From: Jim Bailey
Sent: 14 December 2021 09:30
To: Planning
Cc: Alex Chrusciak
Subject: Planning application 21/03947/F.

Re: Land adjacent to Cotefield House, Bodicote – construction of 5 dwellings – application 21/03947/F.

Figure 3: Pedestrian connectivity

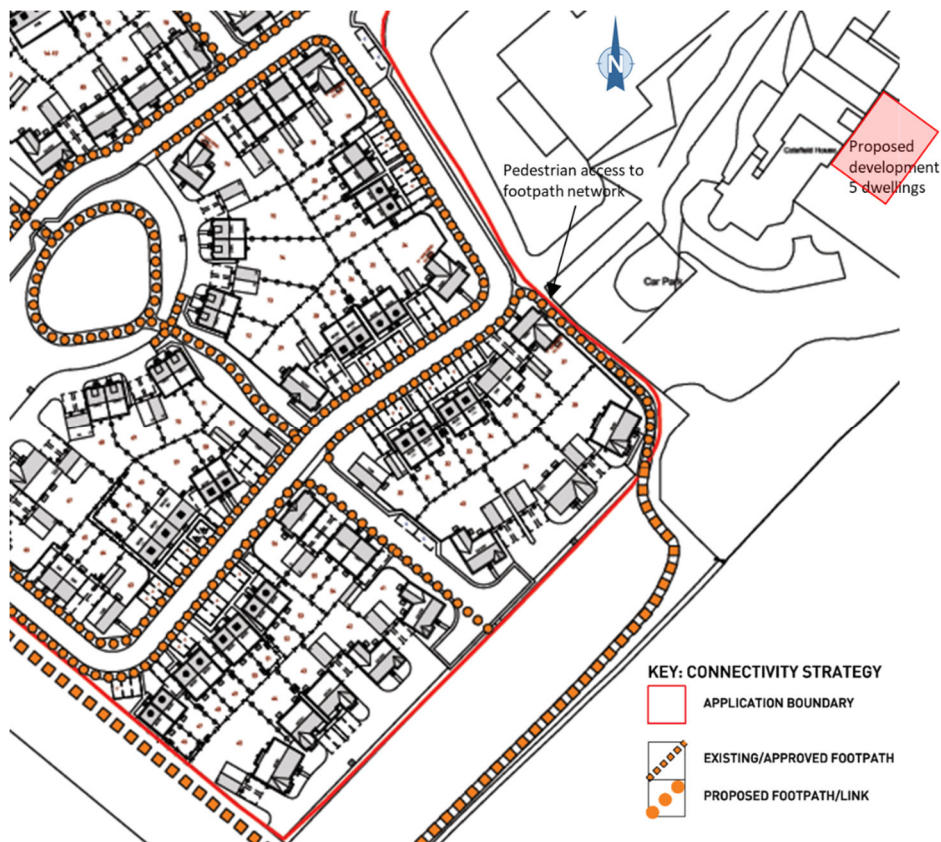
5. **Pedestrian routes** (paragraph 2.6). Figure 1 shows how a private gated access could be provided from the grounds of Cotefield House to the new public footpath, which provides access into residential development and countryside to the south. This will not solve the problem of pedestrians having to walk across a commercial yard/access road to get to the Oxford Road and other amenities. Furthermore, the applicant does not have any legal right of access to the new footpath from this point as the boundary strip of land is in the control of my client.

Plan referred to in the Conveyance  
 dated the *2nd* day of *December* 1961 and made between the  
 W.V.S. Housing Association of the one part and the Oxfordshire  
 County Council of the other part.

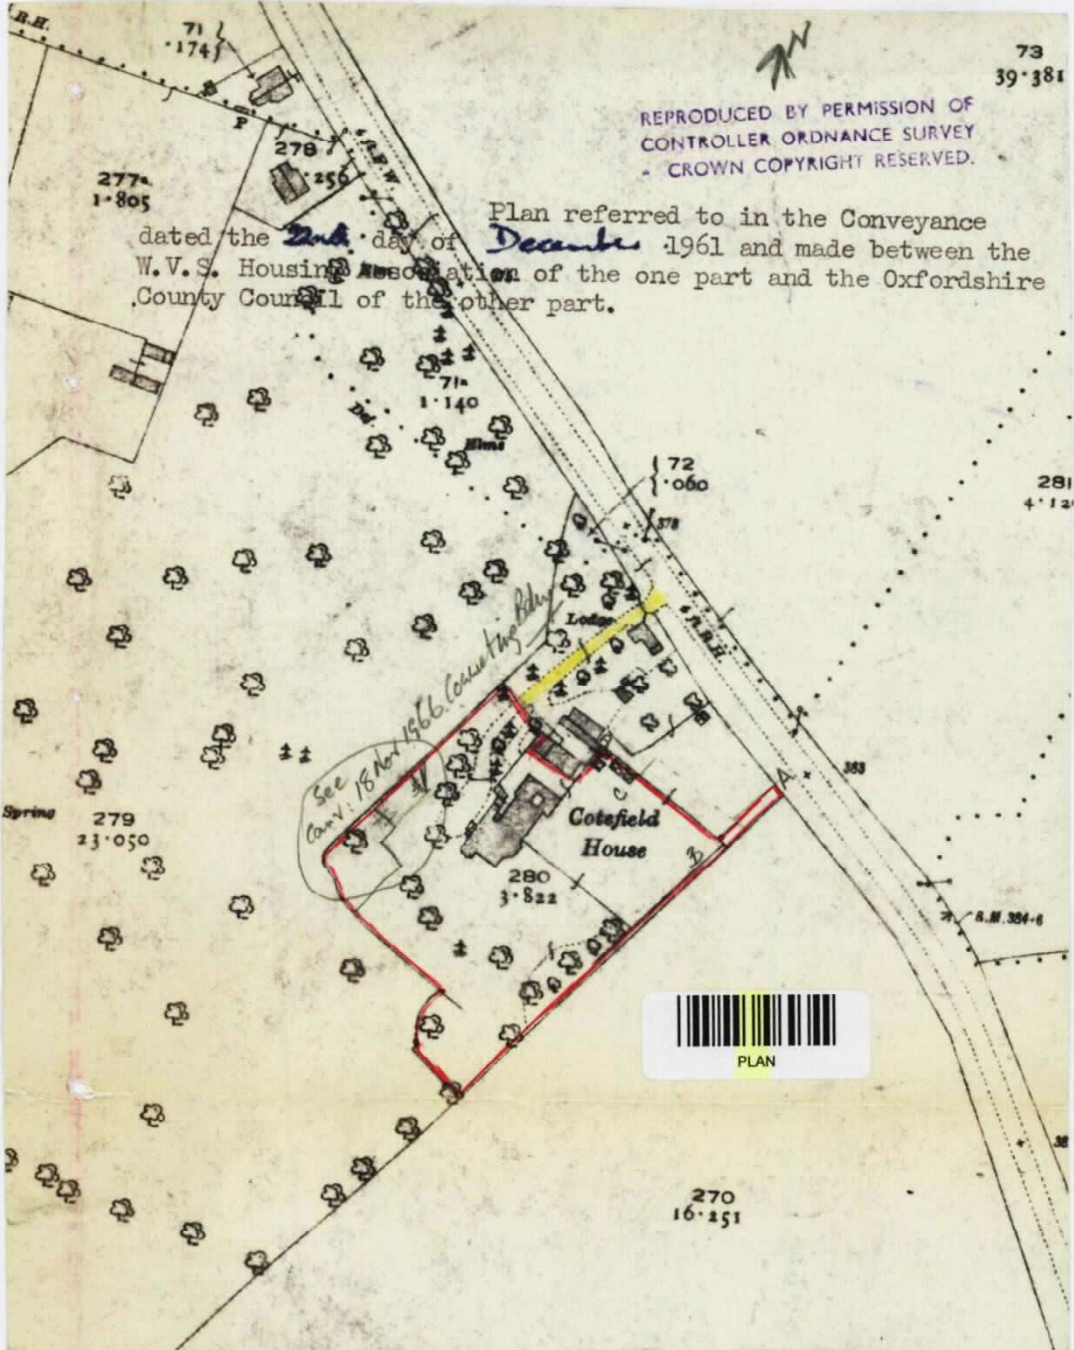
2. **Delineation of existing access** (paragraph 2.3). Submission of a copy of the deeds plan is helpful, but at this scale is only indicative, it does not include any measurements. The alleged road width of 6.68m is simply wrong. Furthermore, the deeds plan and the new location plan, which also does not include measurements, clearly both show the gate in place at the entrance. The gate, as stated above, is not going to be removed, which limits the width of the access to 3m, and not 6.68m or 6.8m as suggested.
